**Subject:** Rezoning Petition Review

**Rezoning Petition #:** 22-082

**Location of Property:** Approximately 13.26 acres located on the south side of W Mallard Creek Rd, east of I-85 and north of Berkeley Place Dr.

NOT FOR CONSTRUCTION
W. MALLARD CREEK CHURCH MULTI-FAMILY
 TRAMMELL CROW RESIDENTIAL
 W. MALLARD CREEK CHURCH RD.
 CHARLOTTE, NC

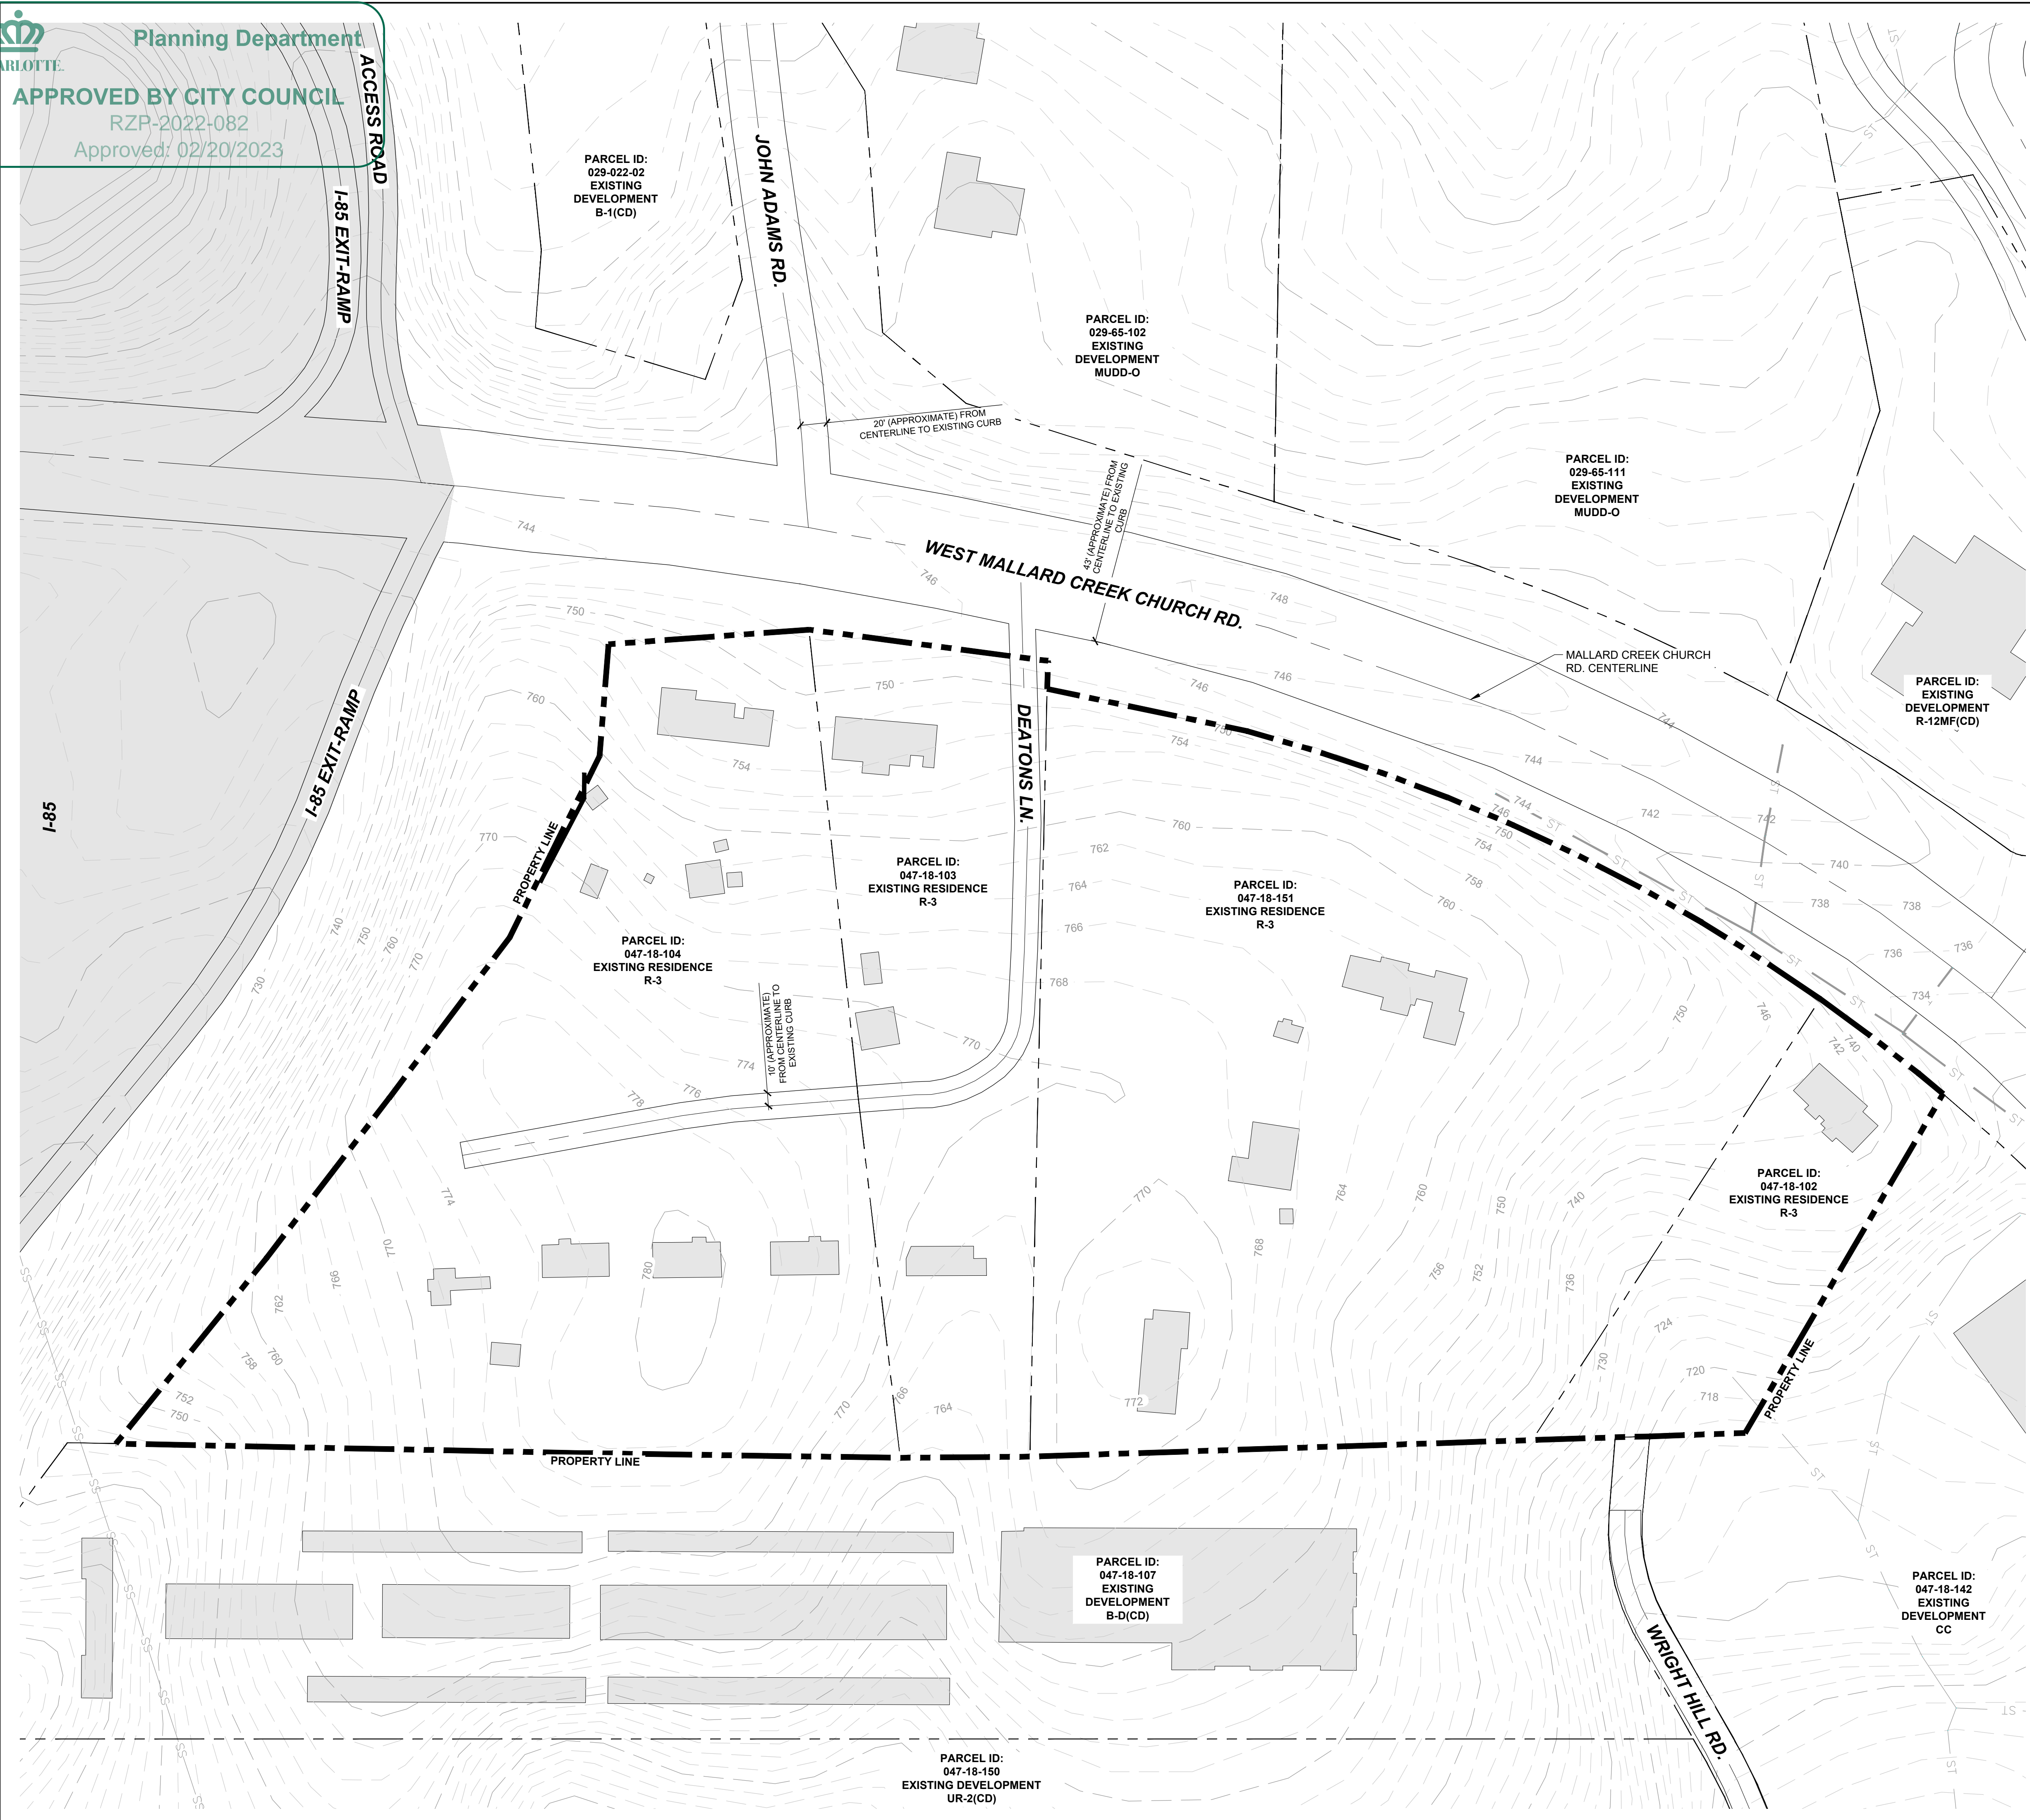
**This property drains to Mallard Creek, which is an impaired/degraded stream, and may contribute to downstream flooding. This project has the opportunity to mitigate future impacts to this stream, therefore, Storm Water recommends placing the following notes on the plan:**

For defined watersheds greater than 10% built-upon area (BUA), construct water quality stormwater control measures (SCMs) designed for the runoff generated from the first 1-inch of rainfall for all new and redeveloped BUA associated with the project. SCMs must be designed and constructed in accordance with the Charlotte-Mecklenburg BMP Design Manual.

For defined watersheds greater than 10% built-upon area, control the entire volume for the 1-year, 24-hour storm for all new and redeveloped BUA associated with the project. Runoff volume drawdown time shall be in accordance with the Charlotte-Mecklenburg BMP Design Manual.

For residential projects with greater than 10% BUA, control the peak to not exceed the predevelopment runoff rates for the 10-year and 25-year, 6-hour storms or perform a downstream analysis to determine whether peak control is needed, and if so, for what level of storm frequency.
